PLANNING CONSULTATION RESPONSE

Application No	2026/0347
Proposal	Change of use to utilise a proportion of an existing outbuilding (Use Class C3) as a wellbeing retreat and meeting space (Use Class Ee and Ec2). Including minor alterations
Address	Copster House, Rag Lane, Thurgoland, Sheffield, S35 7BA
Date of Consultation Reply	27/07/26
Consultee	Highways DC

Photo C Visibility from site Exit to the Rag Lane/Copster Lane Junction

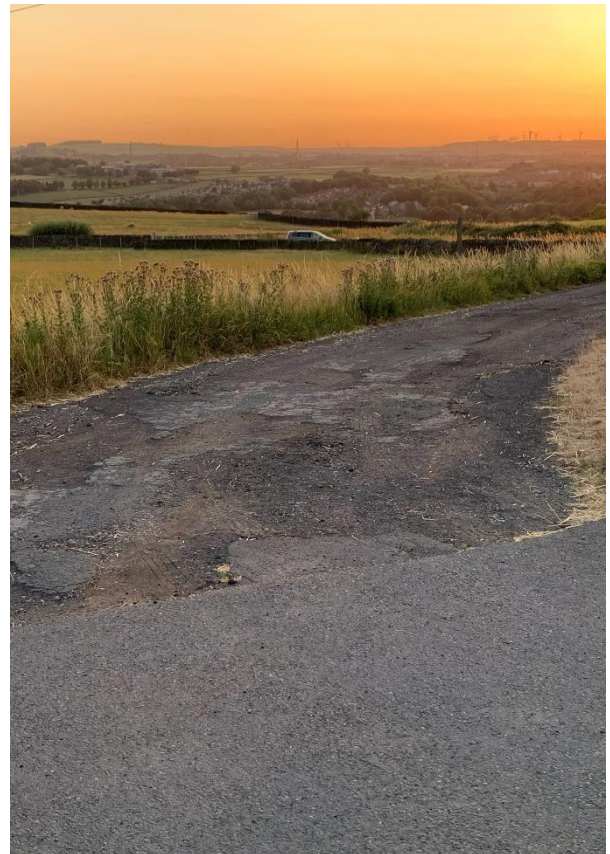
Following previous comments an amended visibility splay drawing has been submitted and is satisfactory to HDC officers. Additionally, photographs have been presented that show two vehicles passing at a farm access between the site entrance and the junction with Rag Lane. HDC officers would still wish to see a formal passing place on Copster Lane to allow safe passage of vehicles. The first ten metres of Rag Lane would also benefit from hard surfacing to prevent debris from entering Rag Lane.
